Thank you for inviting the Lead Local Flood Authority to comment on the below application.

PLANNING APPLICATION CONSULTATION RESPONSE

Application Number:	3/2023/0153
Proposal:	Proposed erection of a 66 bed care home (use class C2) for elderly people with associated parking, access, landscaping and associated ground works, alongside the erection of 3 dwellings following the demolition of nos. 23-25 Old Row.
Location:	Old Row Whalley Road Barrow BB7 9AZ

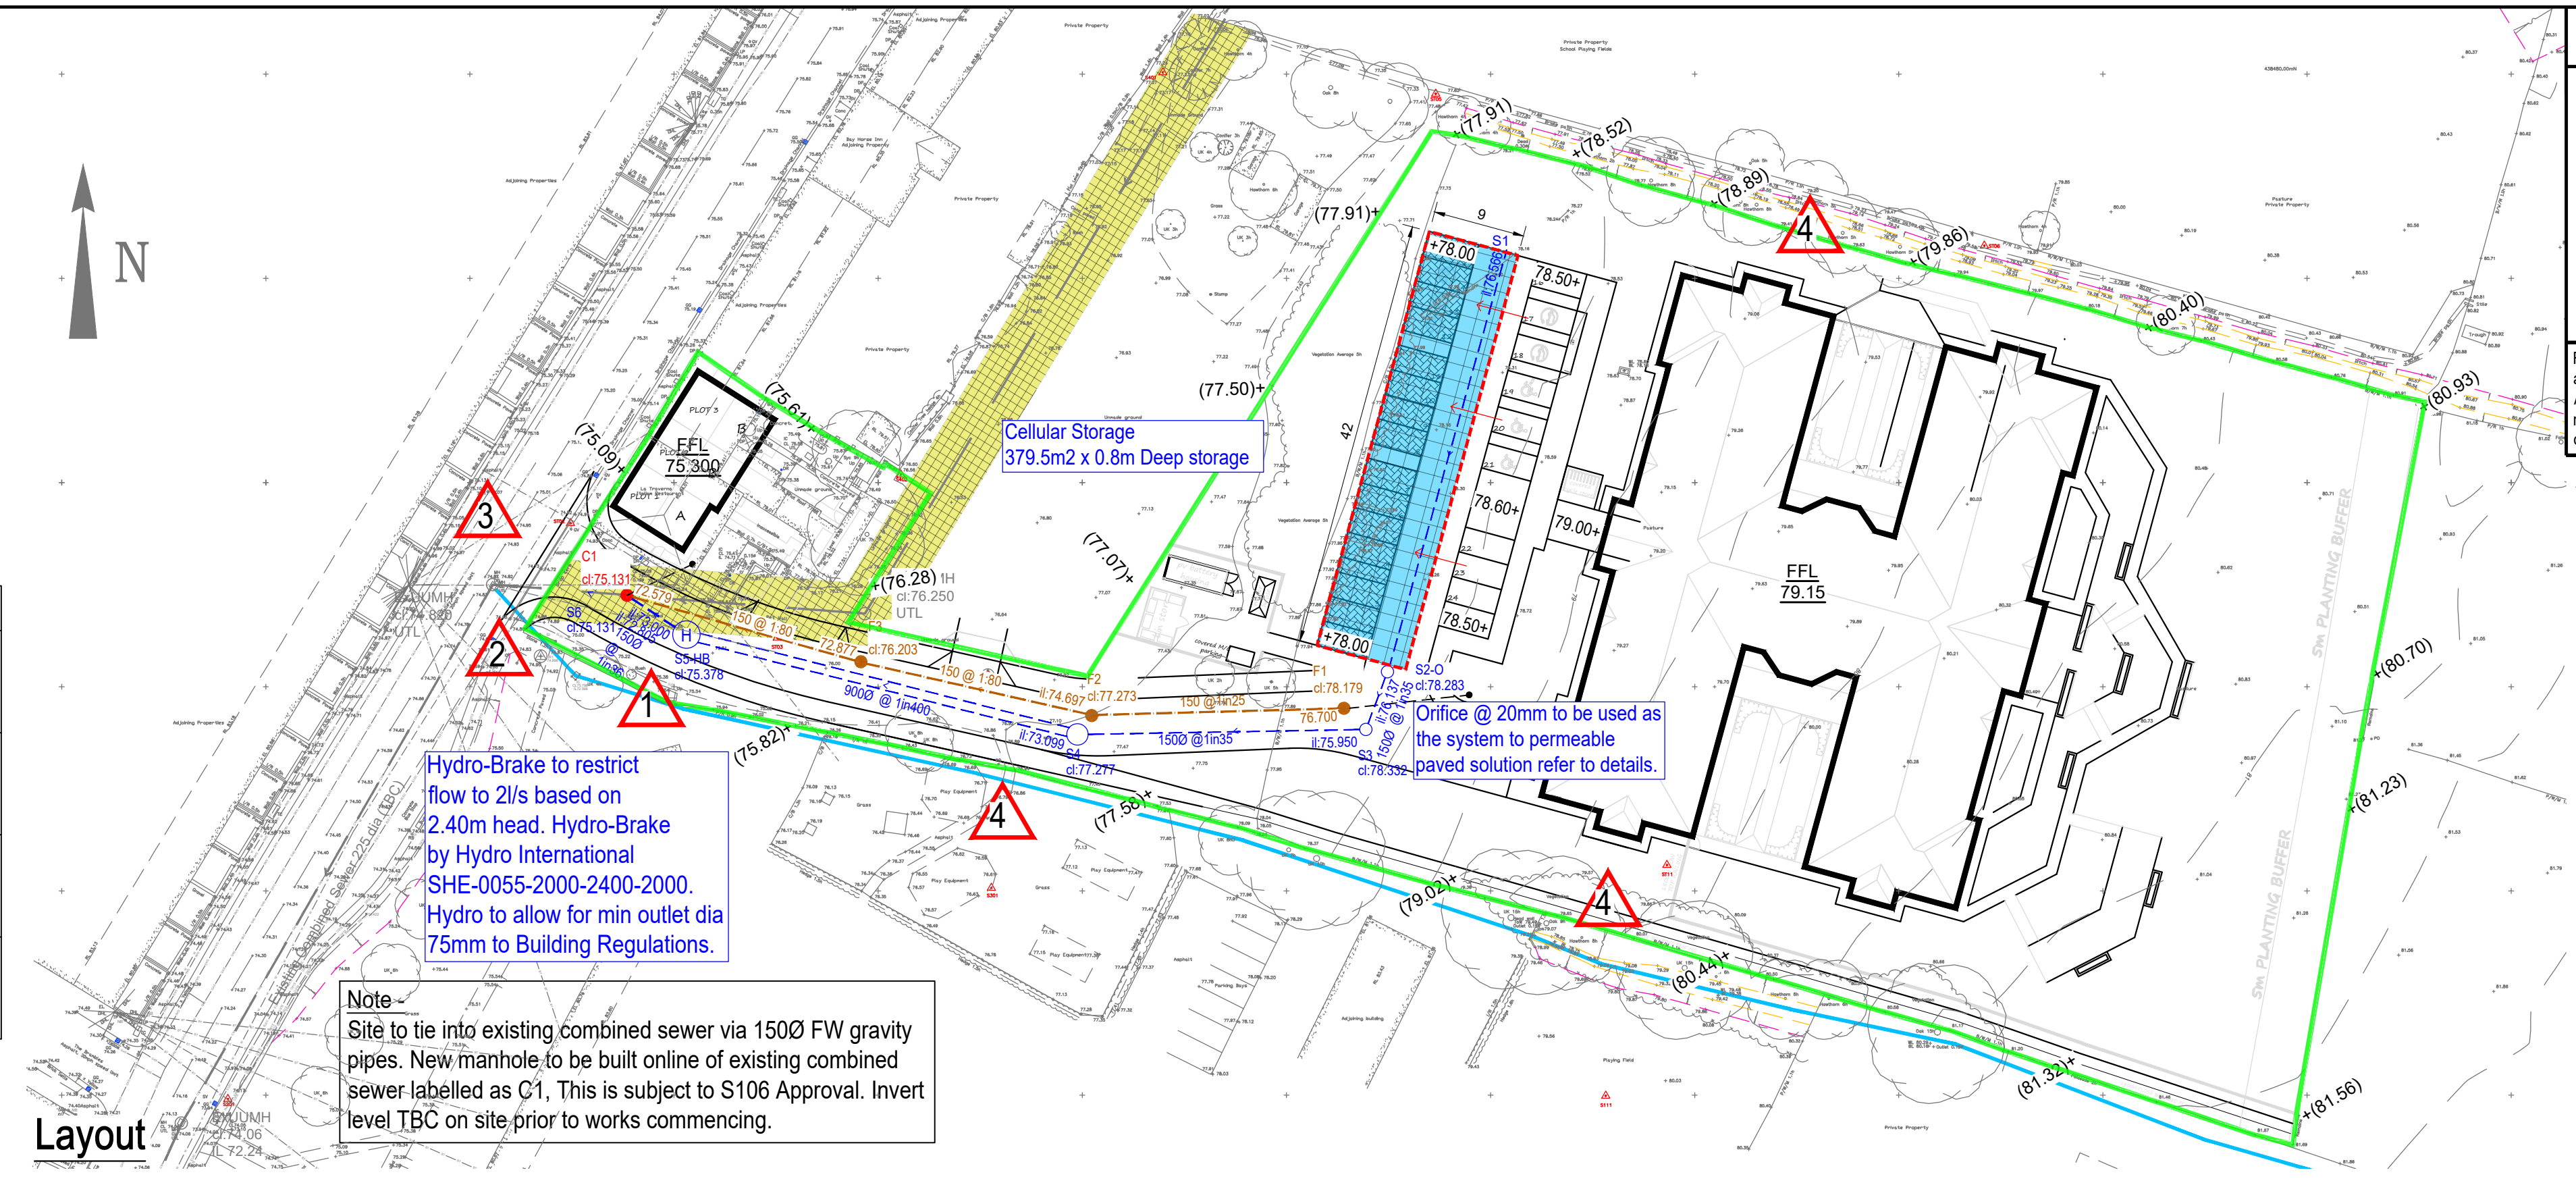
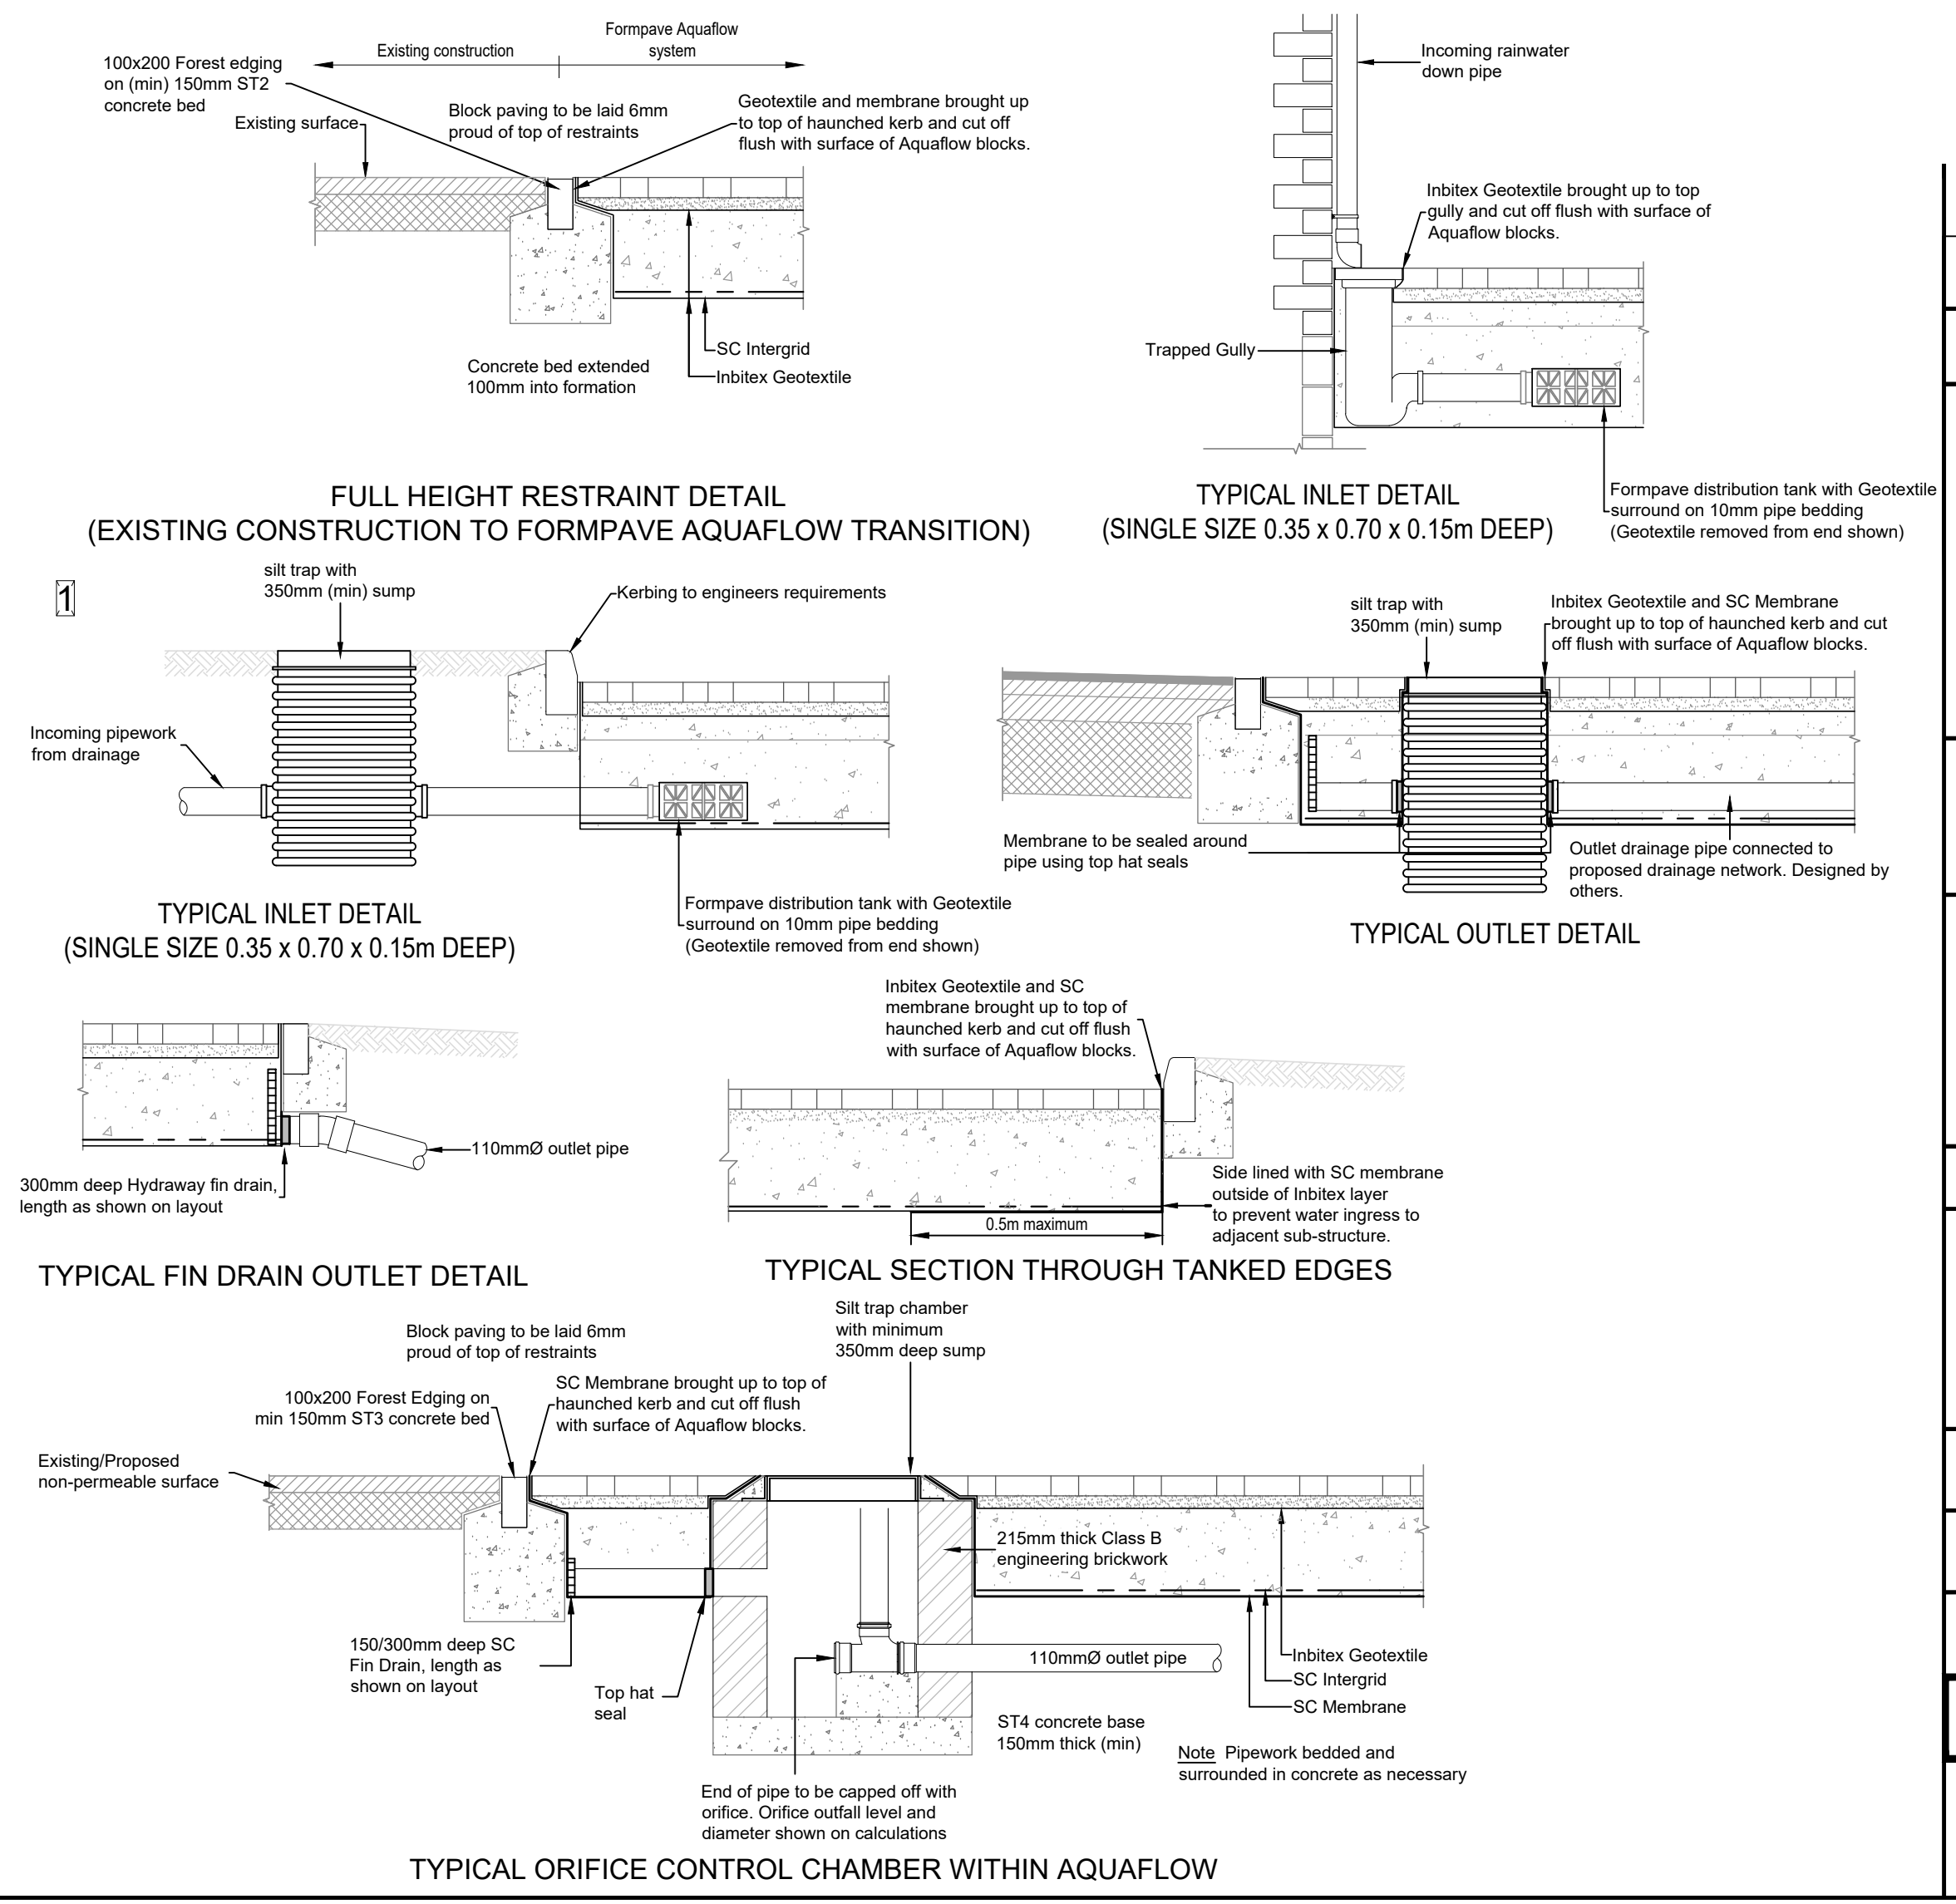
The detailed surface water sustainable drainage strategy shall be based upon the site-specific flood risk assessment and indicative surface water sustainable drainage strategy submitted (January 2023 / Drawing No: 10-01 / RSK) and sustainable drainage principles and requirements set out in the National Planning Policy Framework, Planning Practice Guidance and Defra Technical Standards for Sustainable Drainage Systems. No surface water shall be allowed to discharge to the public foul sewer(s), directly or indirectly, and shall be limited to a maximum peak flow rate of 2l/s.

The applicant has applied the incorrect climate change allowances to the development within the submitted evidence, the correct climate change allowances have been included within condition 1.

- a) Sustainable drainage calculations for peak flow control and volume control for the:
 - i. 100% (1 in 1-year) annual exceedance probability event;
 - ii. 3.3% (1 in 30-year) annual exceedance probability event + 40% climate change allowance, with an allowance for urban creep;
 - iii. 1% (1 in 100-year) annual exceedance probability event + 50% climate change allowance, with an allowance for urban creep
